SKYLINE AT LORSON RANCH FILING NO. 1

STREET AND STORM SEWER CONSTRUCTION PLANS

**AS-BUILT
STREET-STM
FEB 2, 2023**

SF-22-001

SHEET NUMBER C5.1

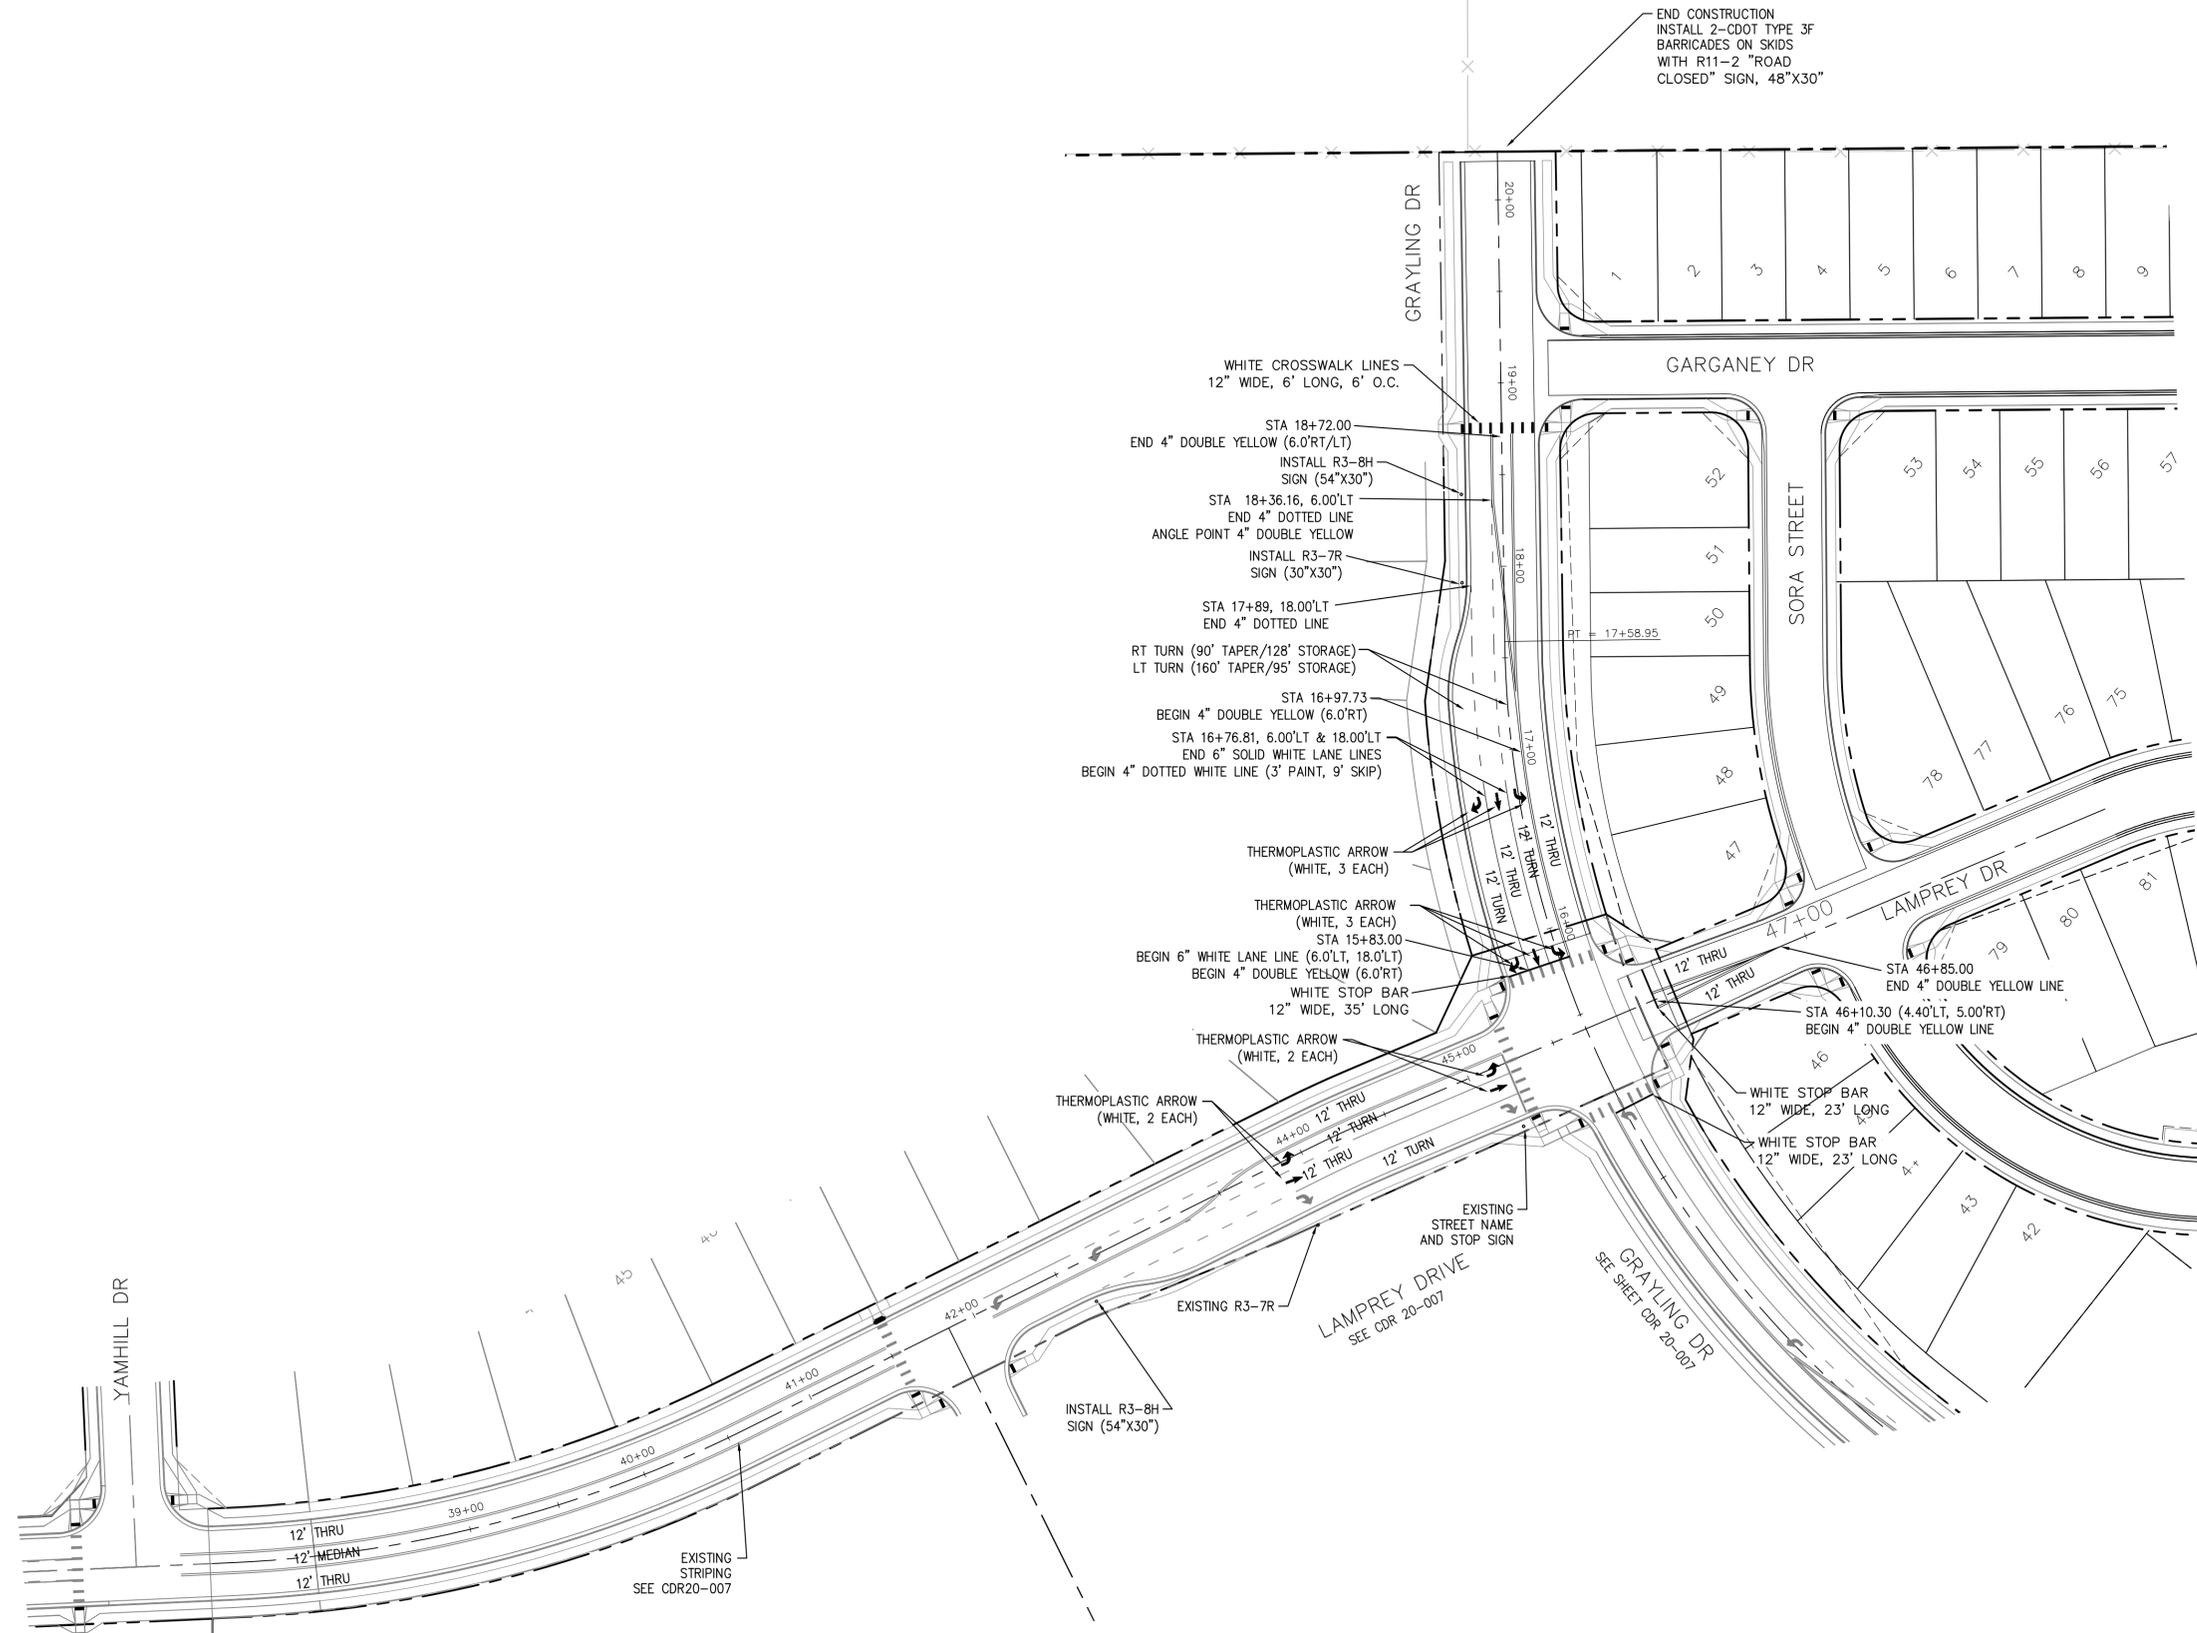
Please update drawings to reflect deferred sidewalks. Please highlight the sidewalks that have been deferred and add a note to clarify the sidewalks have not been built and are deferred per SF221 sidewalk addendum.
